# Written summary of oral submissions made at Issue Specific Hearing 5 on Aviation Noise on behalf of Marathon Asset Management MCAP Global Finance (UK) LLP

- 1.1 This document summarises the submissions advanced by Marathon Asset Management MCAP Global Finance (UK) ("**Marathon**") at Issue Specific Hearing 5 on 6 March 2024. Issue Specific Hearing 5 focused on the impact of the Gatwick Airport Northern Runway Project on Aviation Noise.
- 1.2 The main items for discussion were the relevant civil aviation noise legislation, policy and guidance, the Lowest Observed Adverse Effect Levels (LOAEL) and the Significant Observed Adverse Effect Levels (SOAEL) and other issues around assessment, control, mitigation and compensation.
- 1.3 The hearing opened at 10am at the Sandman Signature London Gatwick Hotel, and closed at 1.19pm.

14.9.1

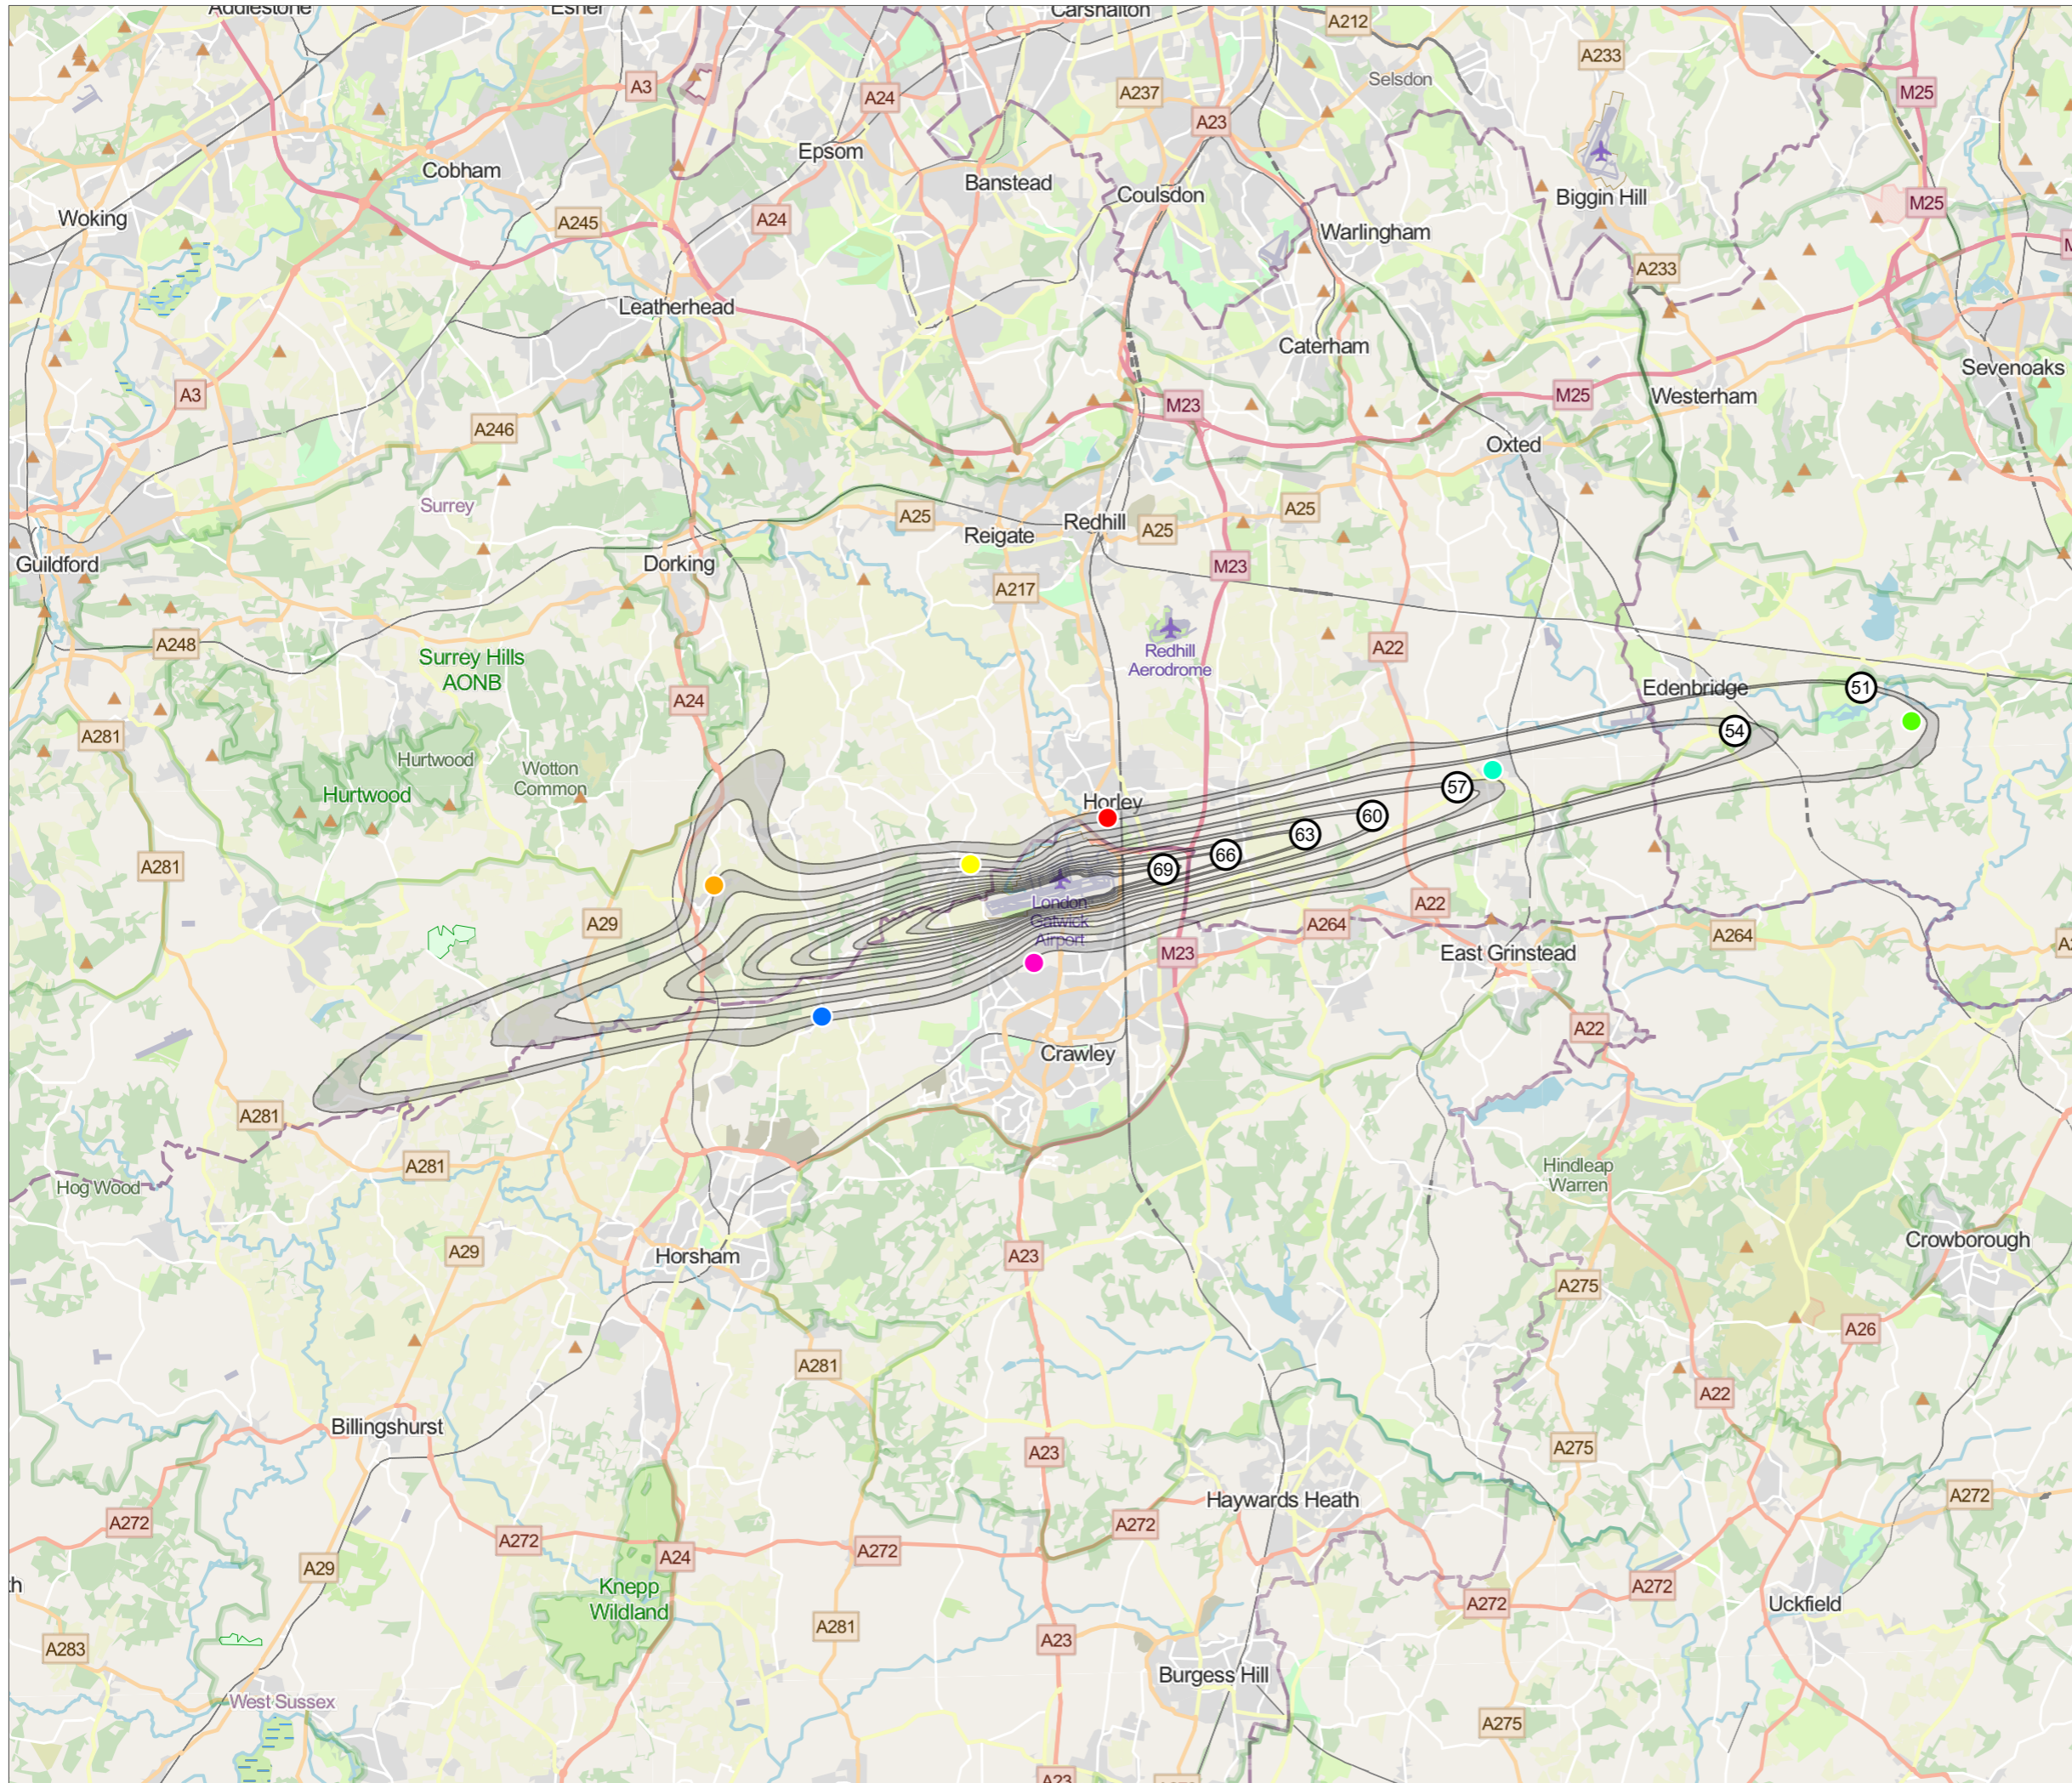
Agenda Item	Summary of oral submission
<b>7.1 Forecasting, modelling, and monitoring overview</b>	<p>It was noted that there is a hope that discussions between the Applicant and Marathon will allow the issues raised to be addressed voluntarily and amicably. The submissions made flagged Marathon's concerns in respect of the extent of assessment of noise effects of the Project on the Holiday Inn.</p> <p>Having reviewed ES Noise &amp; Vibration Chapter 14 [Document Reference APP-039], the Air Noise Modelling Report [Document Reference APP-172] and the Ground Noise Modelling Report [Document Reference APP-173], it is apparent that the Holiday Inn has not been treated as a noise sensitive receptor for the purposes of the noise impact assessment. It is surprising that this is the approach that has been taken.</p> <p>The failure to identify the hotel as a sensitive receptor means that no information has been provided in the ES on future ground noise, additional awakenings due to air noise and construction noise levels are likely to affect the hotel and therefore the relative impact and the significance of this cannot be assessed.</p> <p>It was explained that Marathon's premises are particularly sensitive to noise. They need to provide suitable conditions for sleeping during the night, but also during the day. The reason for this is that they hold contractual obligations to host air cabin crew during layovers. At present internal noise levels at the hotel are well within best practice guidance in the relevant British Standard and we are keen to understand the impact that the proposed DCO may have.</p> <p>It has not been possible to assess the impact, but Ms Girdziusz looked at the closest receptor that has been treated as a noise sensitive receptor for the purposes of air noise and assessment of additional awakenings. The nearest community receptor to the Holiday Inn is Barnfield Community Care</p>

<p>Home, Horley. The relative location of this receptor is shown in Figure 14.9.1 of APP-064 ES Noise &amp; Vibration Figures Part 2.</p> <p>Results provided in Tables 4.2.7 and 4.2.14 of the Air Noise Modelling Report [Document Reference APP-172] indicate that there may be as many as 20 additional night-time events that exceed the 60 dB <math>L_{Amax}</math> threshold and 65 events that exceed the 65dB <math>L_{Amax}</math> threshold during the daytime.</p> <p>If the same increase is likely at the Holiday Inn premises this could have a significant effect on the ability for my client to maintain their contractual obligations relating to cabin crew layovers and also risk reputational damage associated with affected general hotel patrons. However, at present, we are unable to gain certainty due to the lack of assessment.</p> <p>It was acknowledged that the parties are engaging on technical noise matters and the receipt of additional information provided as part of these discussions, which Marathon will review and will provide an updated summary in our written representations.</p>
